From: Julie Grieves on behalf of Planning.Responses
Sent: 25 July 2019 09:21
To: Planning Scanning
Subject: FW: Mistletoe Farm, Horsemere Green Lane. CM/13/19/RES; Revised Drainage Proposals

I have considered both the proposed drainage strategy (Escher Silverman, dwg.no. 602-04, Rev B) and Tree Retention & Protection Plan (Lizard, dwg.no. LLD1394-ARB-DWG-002, Rev 01) alongside one another, to understand the likely impact on retained trees.

Tree Retention & Protection Plan

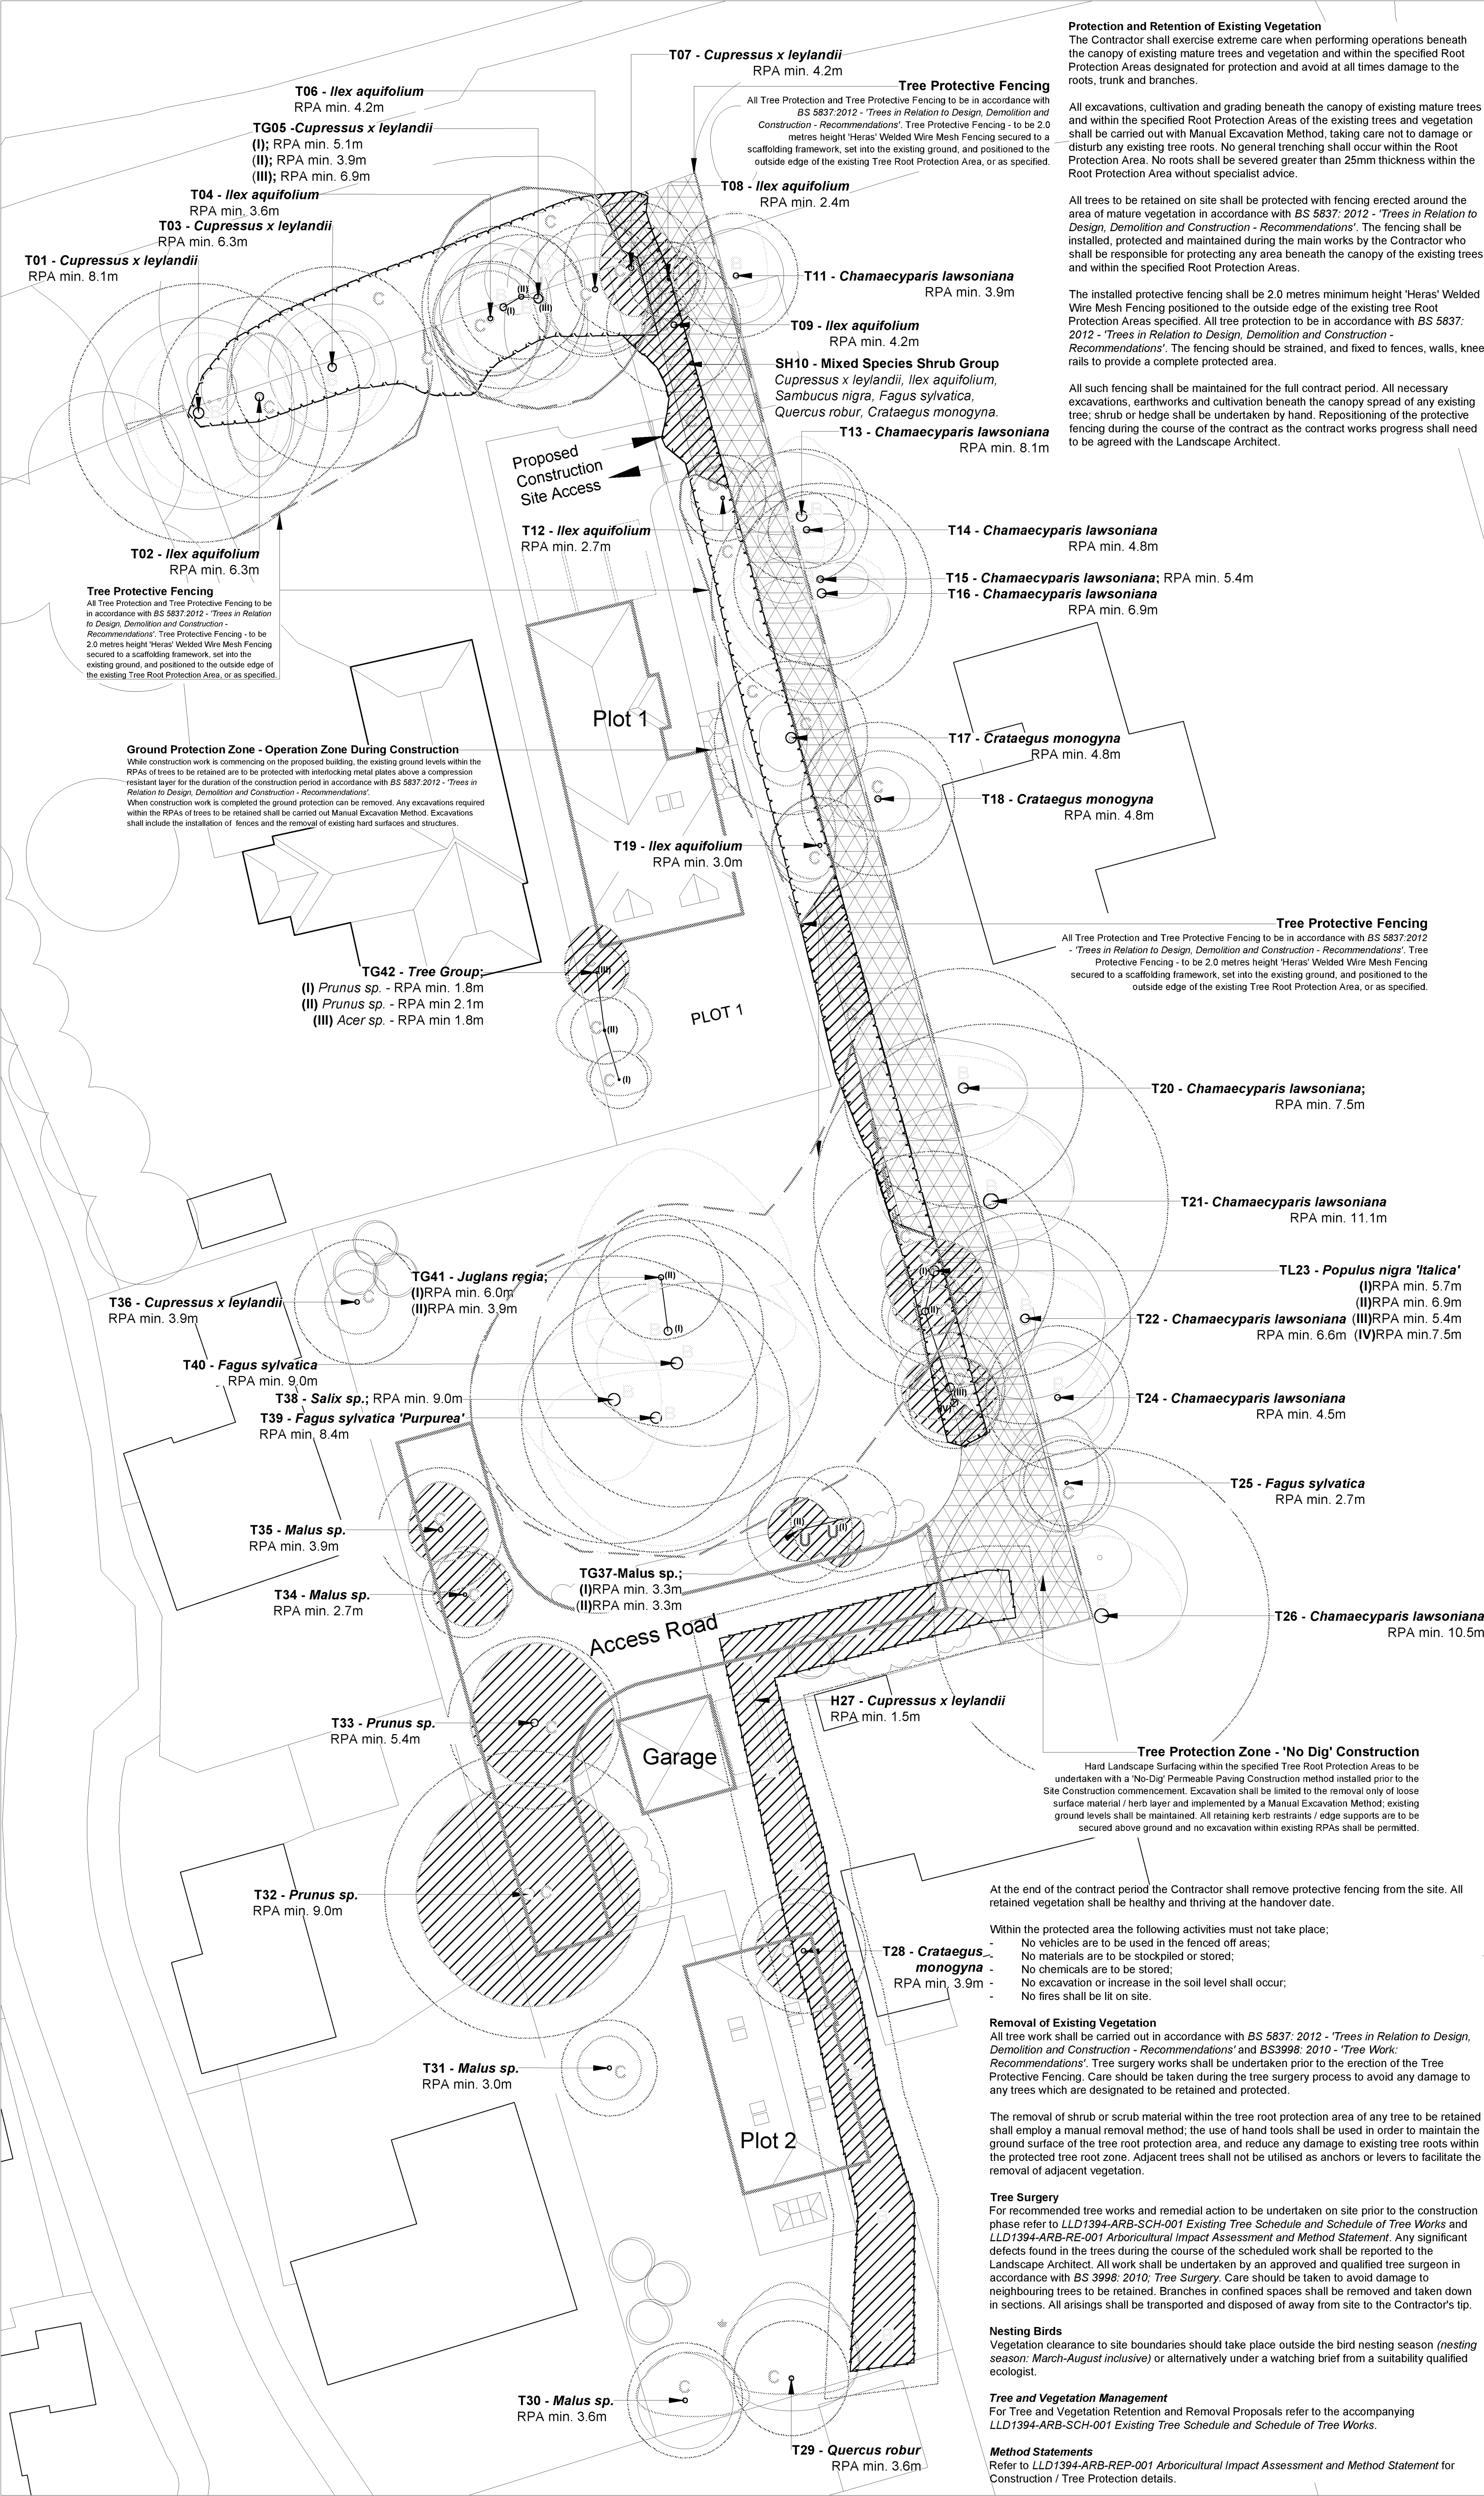
I have estimated the lateral extent of Root Protection Area (RPA) incursion required to implement the swale, as follows:

T36 Leyland cypress (Cat C) – Proposed for retention and not at risk from current swale proposal. Could be sacrificed with no significant loss of visual amenity (to facilitate an alternative scheme?).

T38 Willow (Cat B) – Approx. 7m encroachment into 9m RPA.

T39 Beech (Cat B) – Approx. 4m encroachment into 8.4m RPA.

T40 Beech (Cat B) – Approx. 4m encroachment into 9m RPA.

T41 2x walnut (?) – Approx. 1.5 & 2m encroachment into 4m and 6m RPA.

TG42 Mxd. *Rosaceae* (Cat C) – 1 of 3 trees already identified for removal. It looks like the other two trees will have to be sacrificed to implement subterranean elements of the scheme.

For all those trees highlighted in bold text, the RPA incursion is damaging to an extent far beyond that which is required to guarantee their long-term survival. This group represent the most significant arboricultural feature on the site, which the LPA have recognised by identifying the central beech tree (T40) for preservation (TPO) and seeking a revised plot layout that also allows for successful retention of its companion trees.

I would be prepared to accept the loss of some trees in the group (T38, T41) and outlier (T36) to accommodate a swale (if no reasonable and practical alternative exists) – but the RPA of T39 and T40 should remain sacrosanct. Ideally we should seek to have RPAs of all those trees (in bold type) left unaltered.

In conclusion, I find the proposed location for the swale to be wholly unacceptable and would expect the applicant/agent to provide an alternative scheme that meets with your requirements and fully respects T38 – T41 incl. or consider an alternative site layout.

Thank you for sending over the revised plan. I believe there is some conflict between what you are proposing and the tree protection plan (attached).

The permeable paving for plot 2 looks like it could only be located in the T furthest round on the road rather than at the junction of roads 1 and 2. The swale also appears to be within a no dig area.
